SUBMITTAL REVIEW COMMENTS

AE 0072-19 Mercer Island Transit Interchange

Submittal No./Ref./Title: 60% Submittal

AHJ: City of Mercer Island

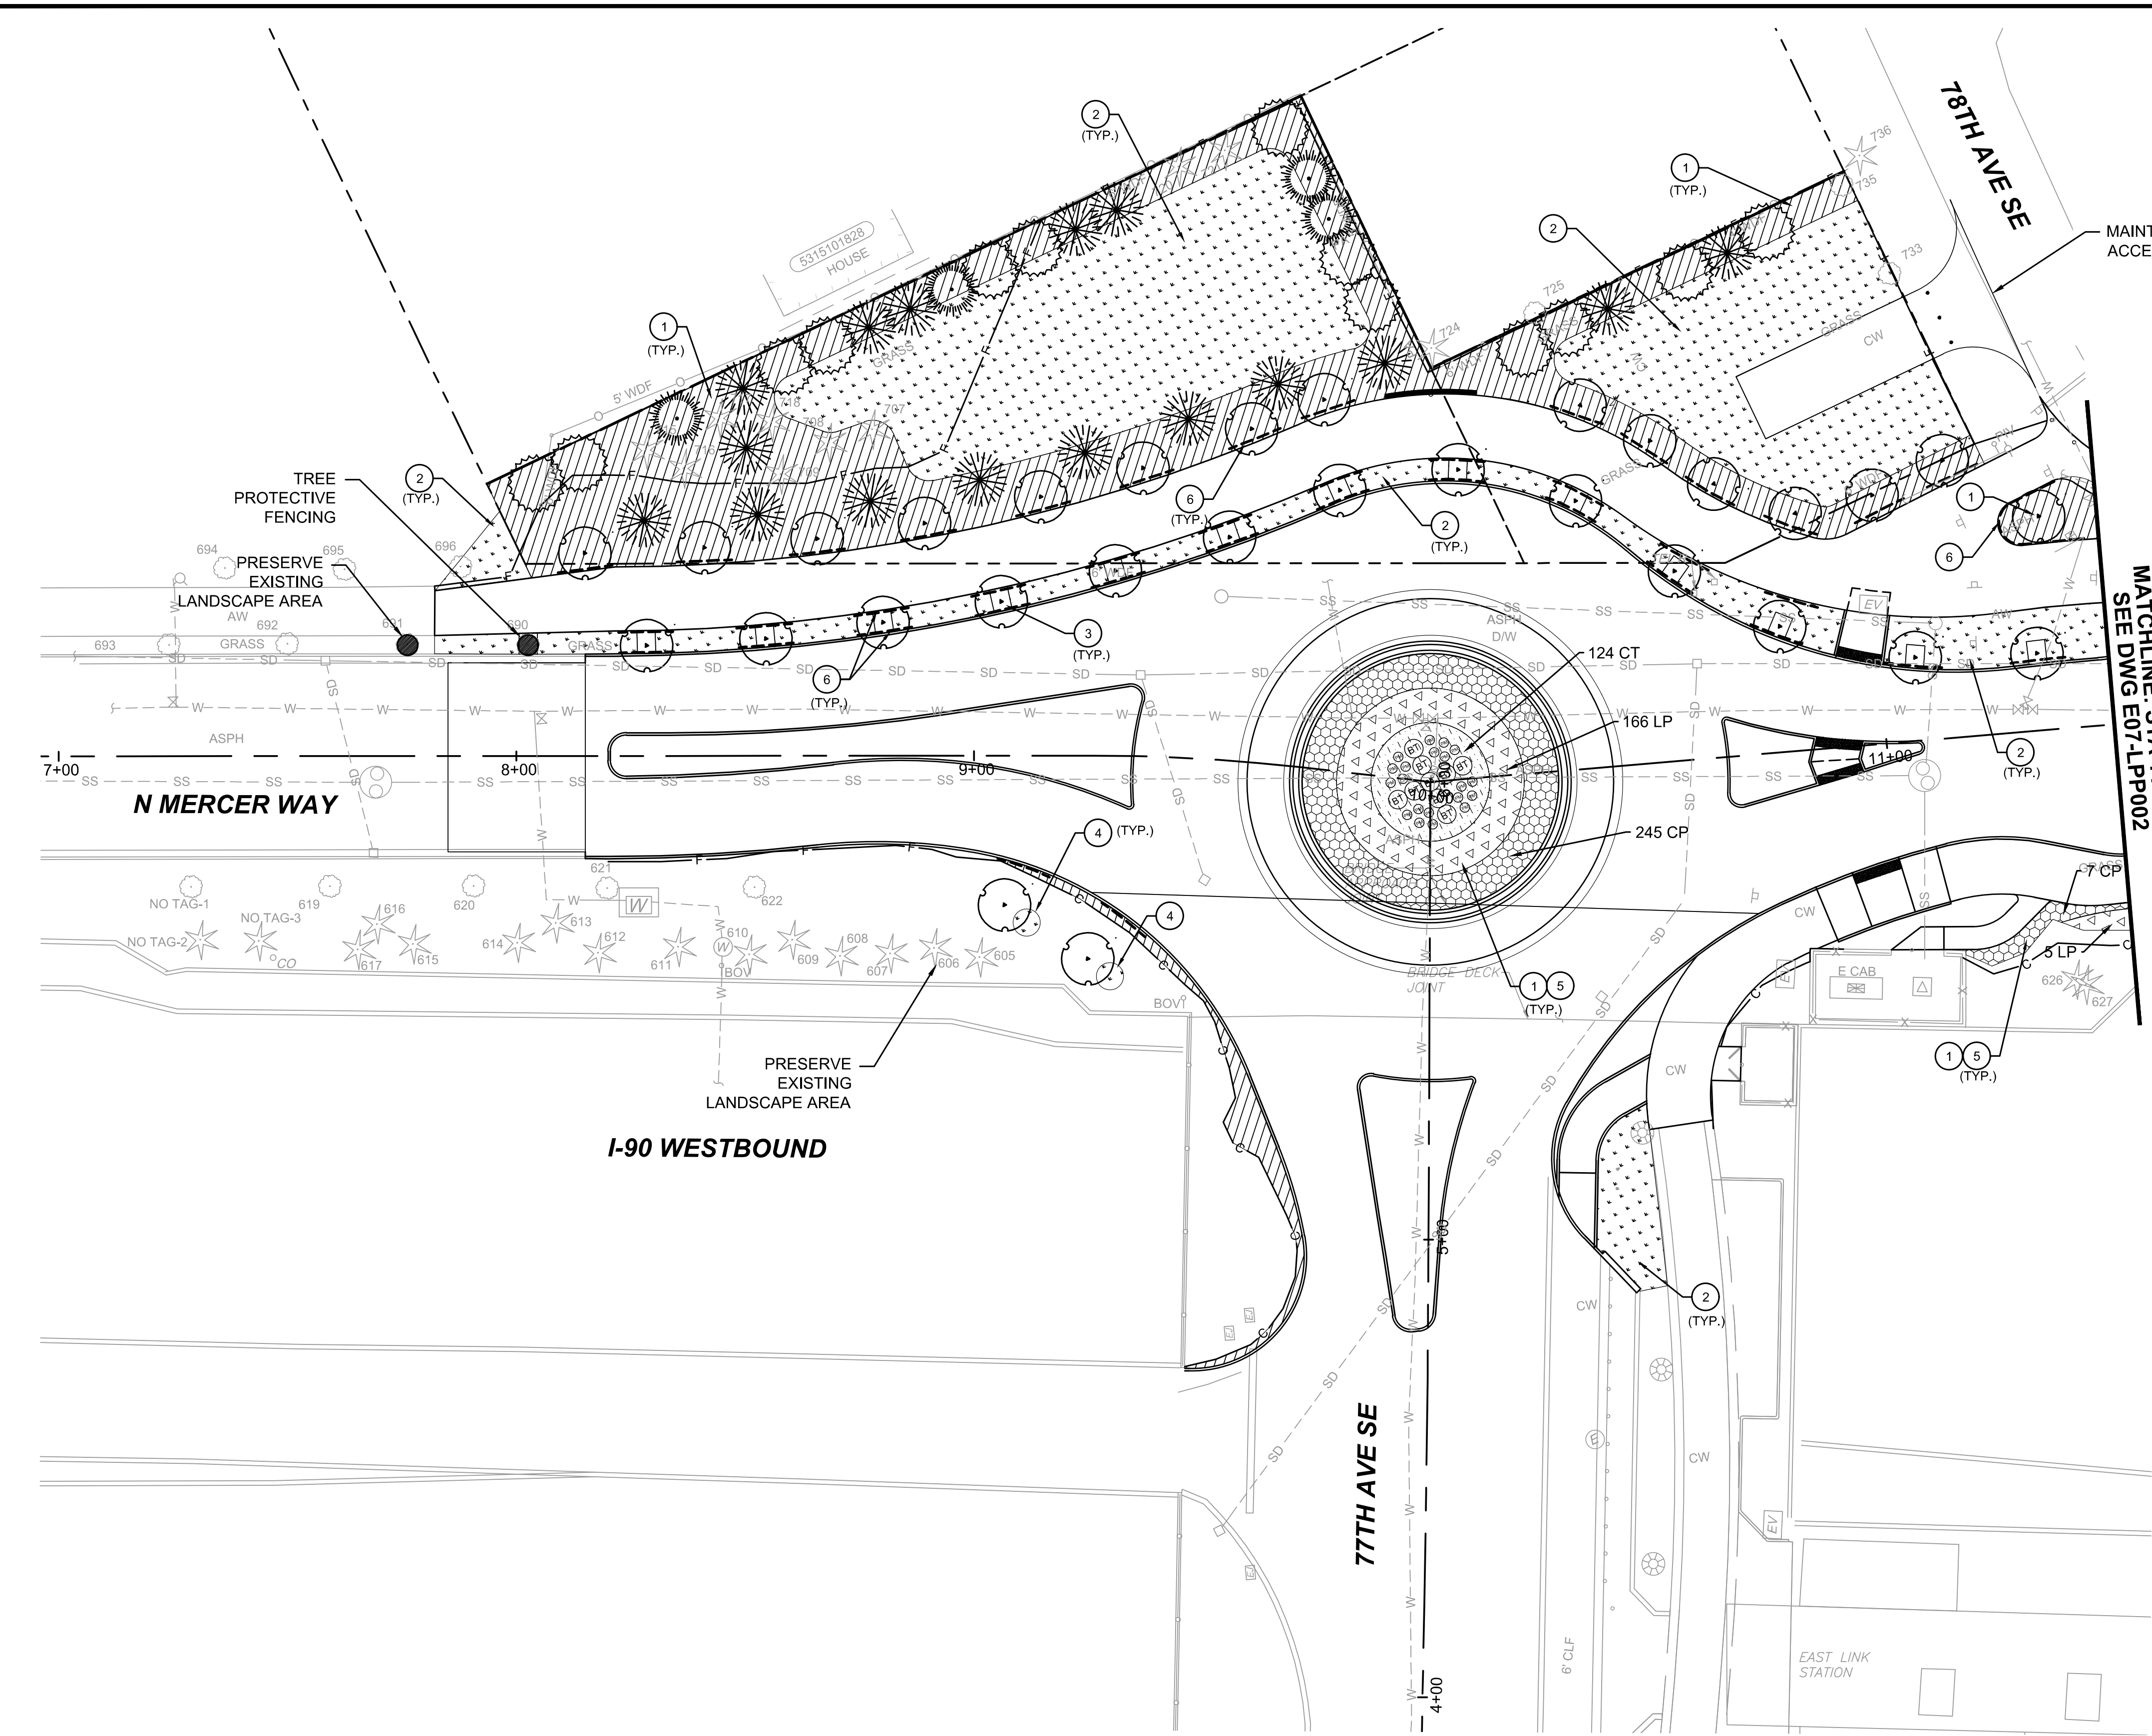
PK12	60% Contract Plans	LPP001	PW	CMI suggests tree selection in the planting strip on north side of roundabout to be <i>Parrotia persica</i> 'Persian Spire' to match new planting to the west. Or keep <i>Carpinus</i> sp. and incorporate a larger suspended pavement system to support this size tree.	Will review/revise.	90
PK13	60% Contract Plans	LPP001	PW	Which agency will maintain the plantings on the new ROW properties?	ST proposed to dedicate ROW to CMI as code requirements make the remaining property undevelopable.	CD
PK14	60% Contract Plans	LPP002	PW	Find a substitute for <i>Amelanchier alnifolia</i> . This plant is an alternate host of a rust that affects	Will review/revise.	90

DRAWING No.:  
**E07-CRY002**  
LOCATION ID:  
E07  
SHEET No.:  
9 OF 104  
REV:  
0

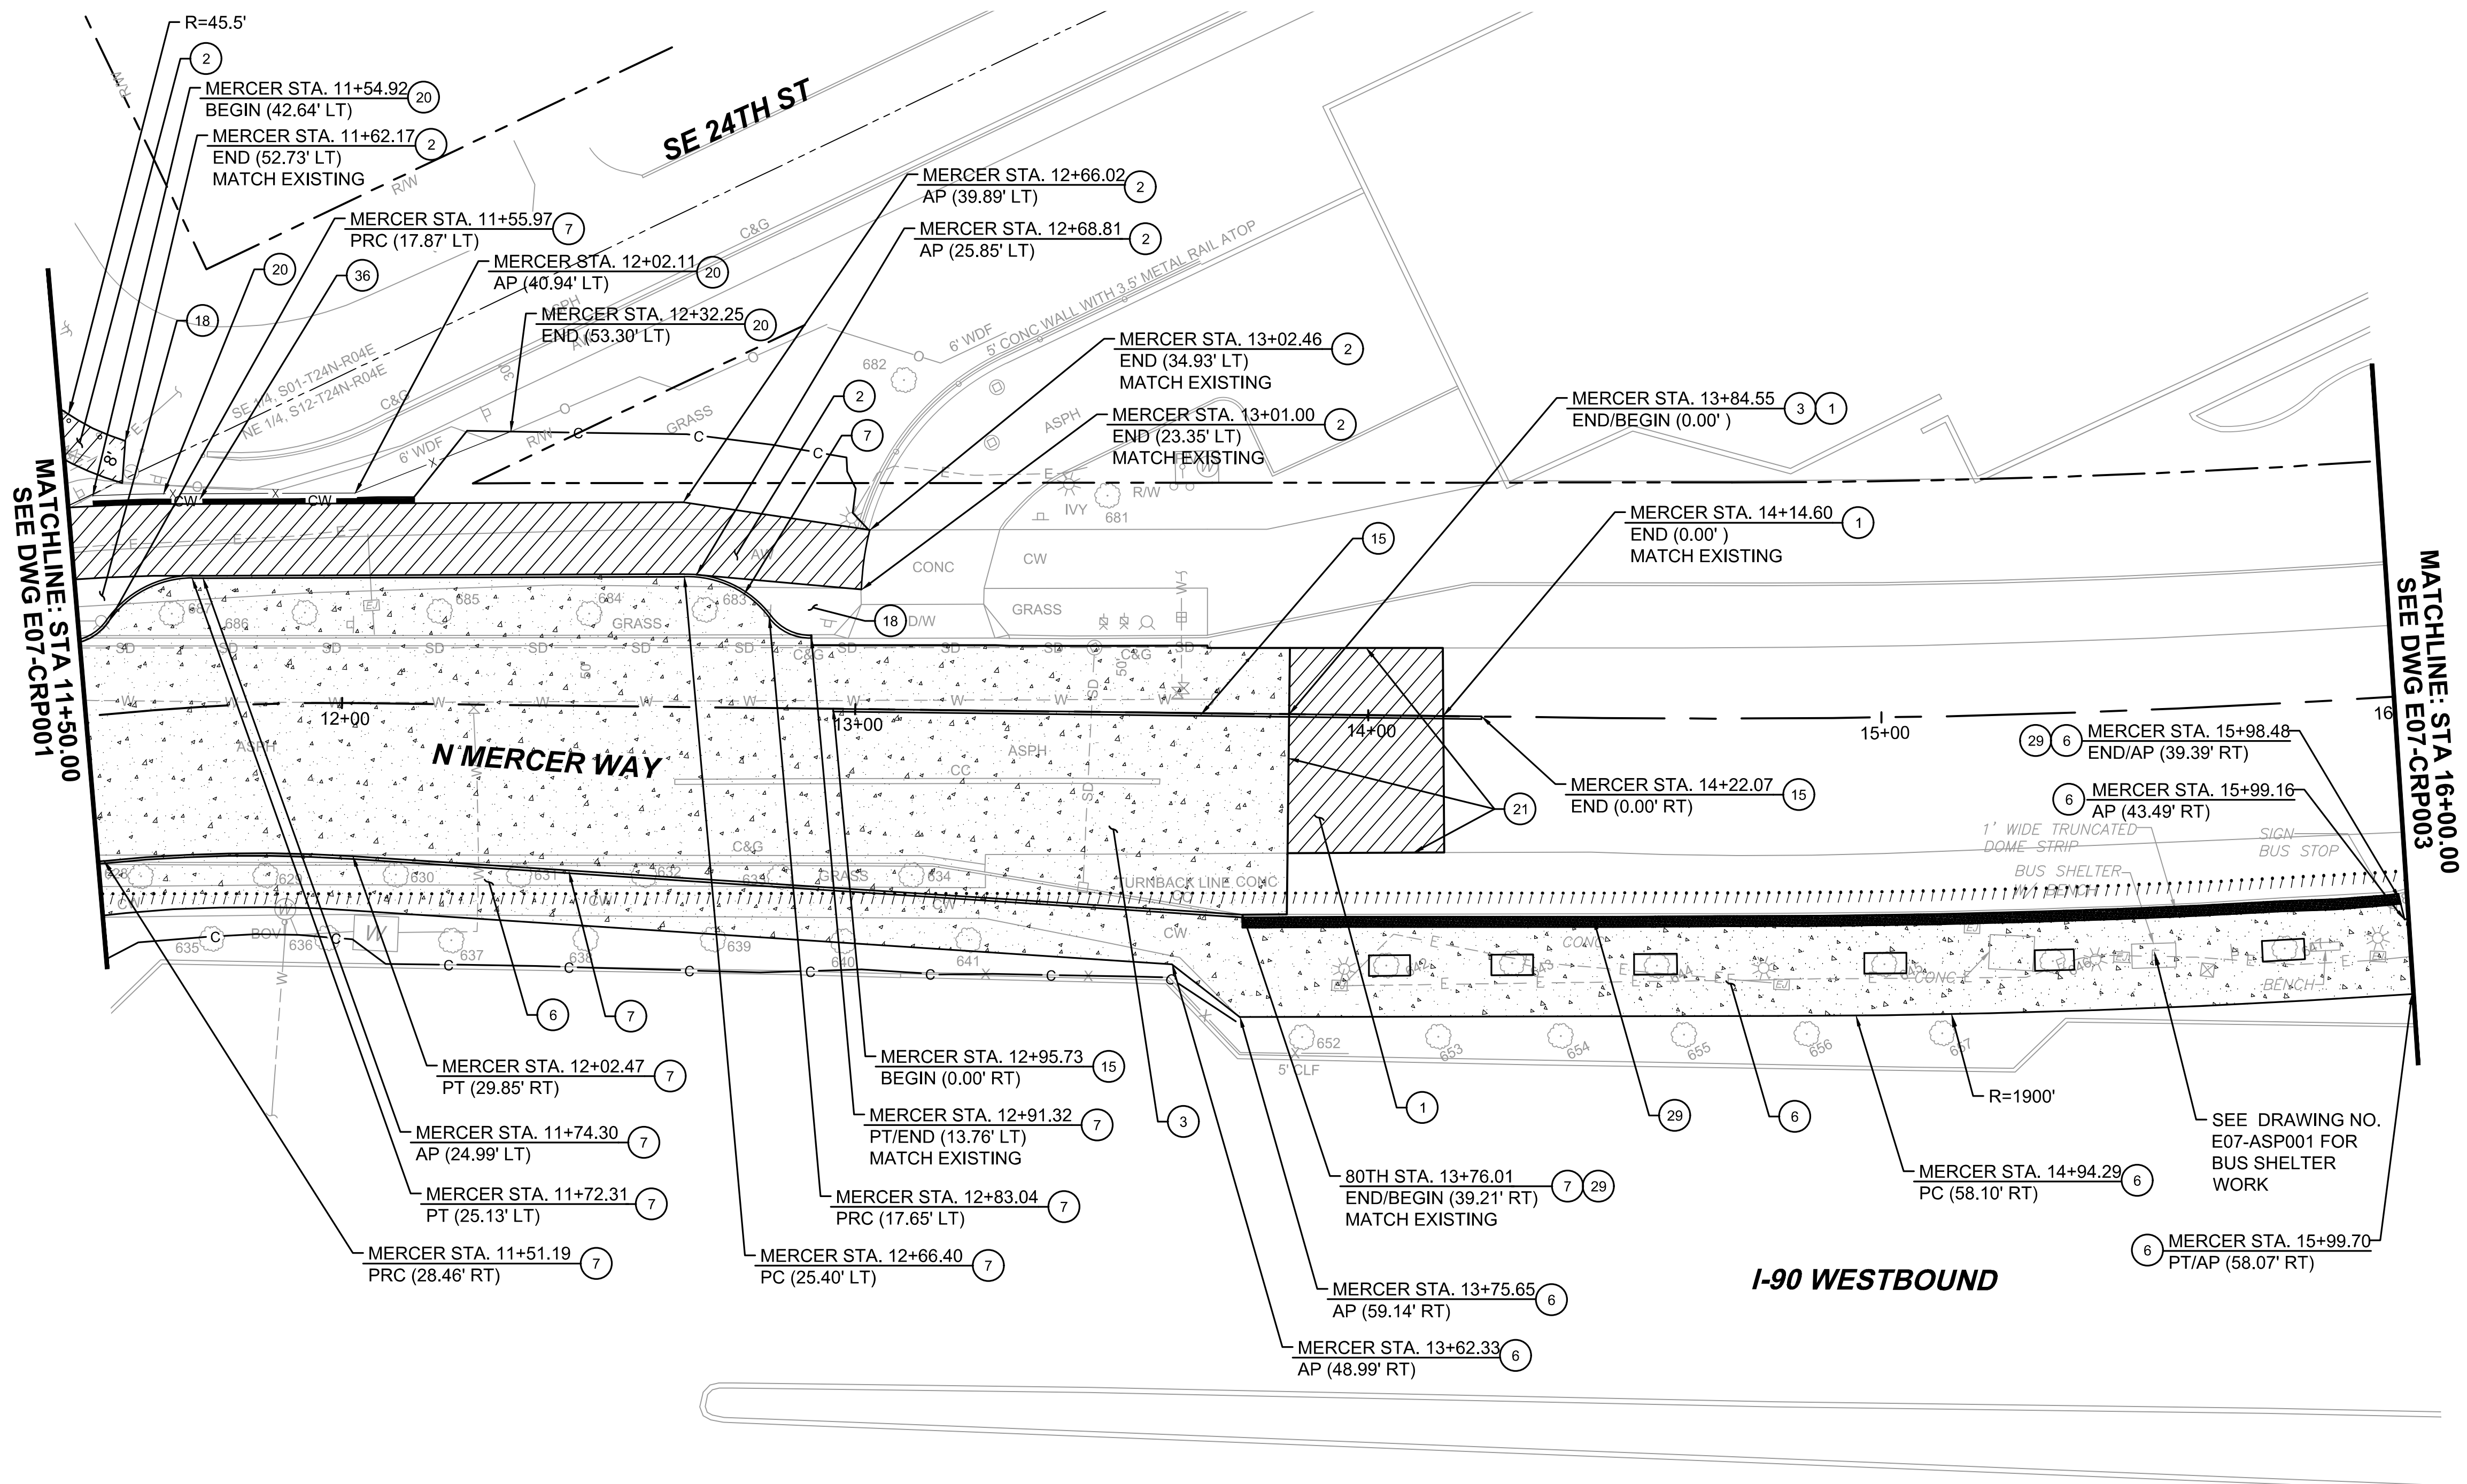
PK2	60% Contract Plans	CRY003 and others	PW	Emergency Pullout on 80th – This feature is poorly defined in the plan set. It needs additional detail including features that are going to clearly delineate it from public access areas. Recommend that A&E consider orienting stairs north-south to reduce the visual cueing that this provides access to/from the headhouse. As depicted it presents as an invitation to the public.	To be revised. Additional signing and striping to be included.	90
PK3	60% Contract Plans	CSP001	PW	Trees in planting strip on north side of NMW (Site Prep Note 5 callout): Tree survey is out of date. These trees are new plantings less than 6" diameter. According to General Note 3, they would be destroyed. CMI would like the trees protected or dug up and delivered to parks nursery at Luther Burbank Park.	New survey to be conducted with Arborist. Tree salvage to be noted in plans.	90
